DOC18/92845-01
SSI 16-7485

RE: SSI 16_7485 - SUBMISSIONS & PREFERRED INFRASTRUCTURE REPORT AND DRAFT CONDITIONS OF APPROVAL - REQUEST FOR EPA COMMENT

Attachment 1 - SPIR

Figure 2-1 Indicative White Bay civil site (C11) layout

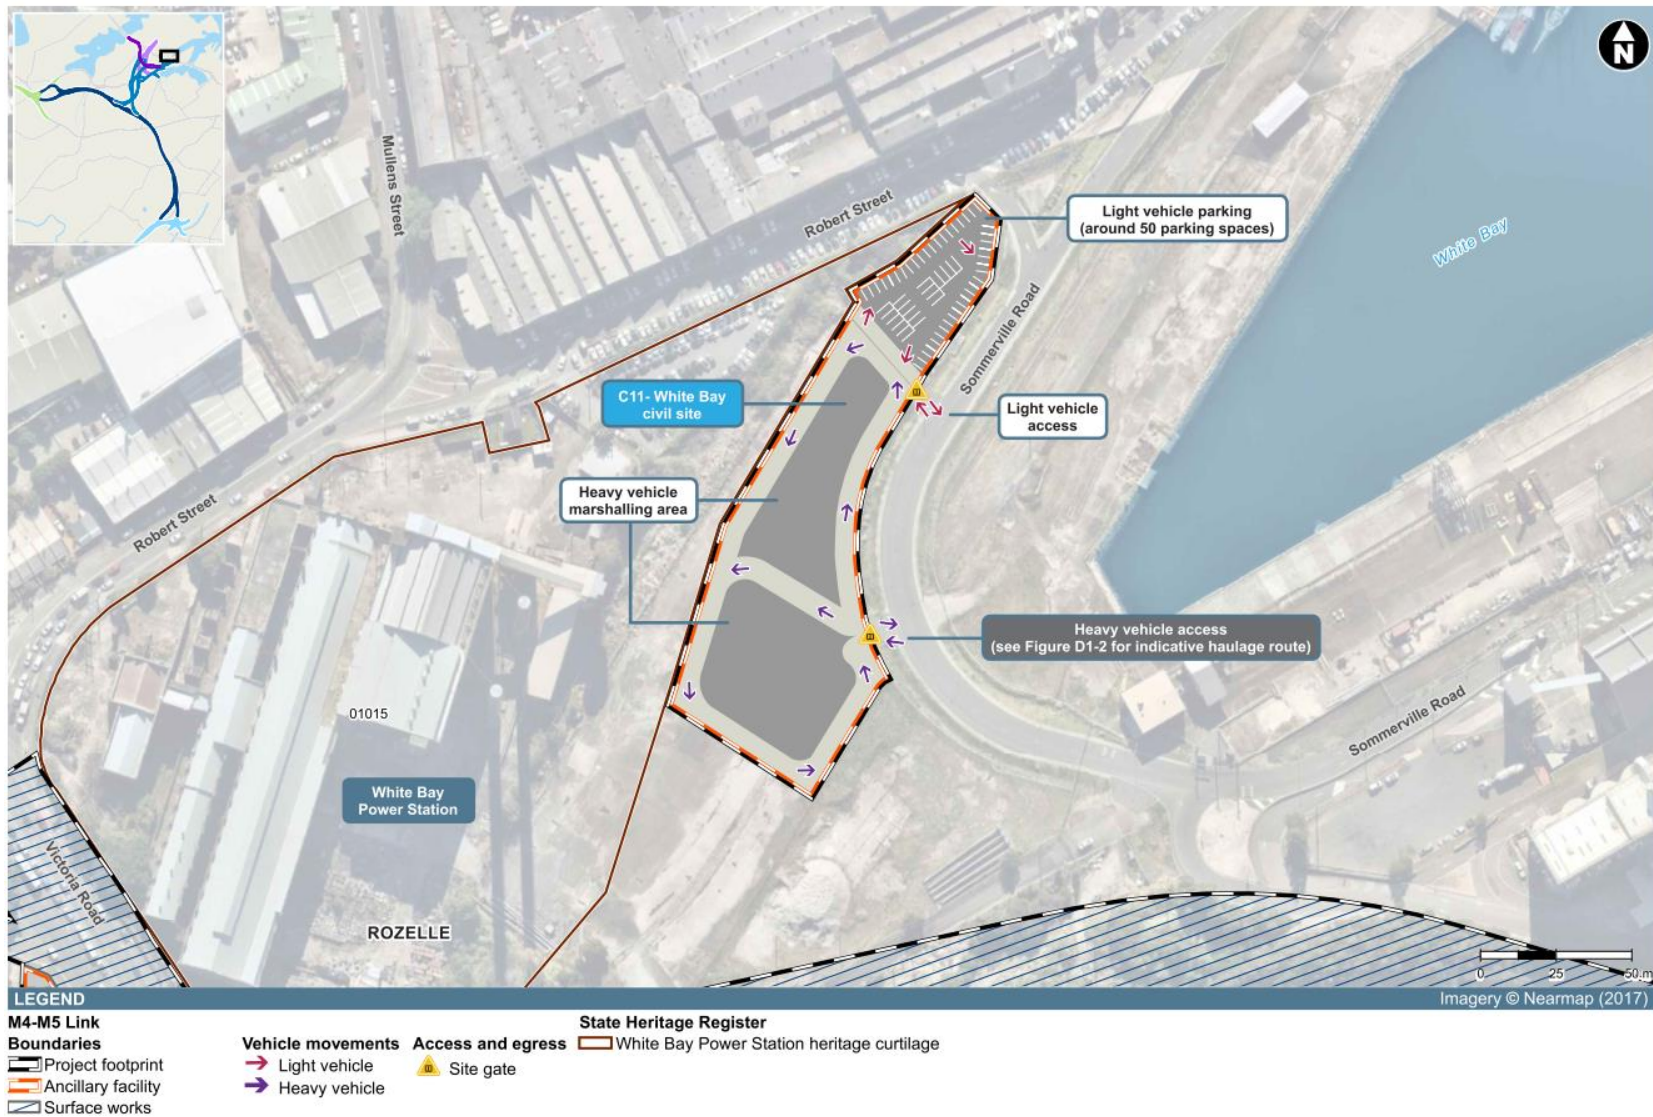
Addition of the White Bay Civil Site (C11)

There is no cumulative assessment of construction and operation noise from White Bay civil site with other non-M4-M5 works in the area.

Minor exceedances of the noise management levels and sleep disturbance criteria are predicted at residential receivers from C11 operations during the night time. As for other works proposed outside of standard construction hours, detailed and robust justification for night-time operations at the C11 Site is required.
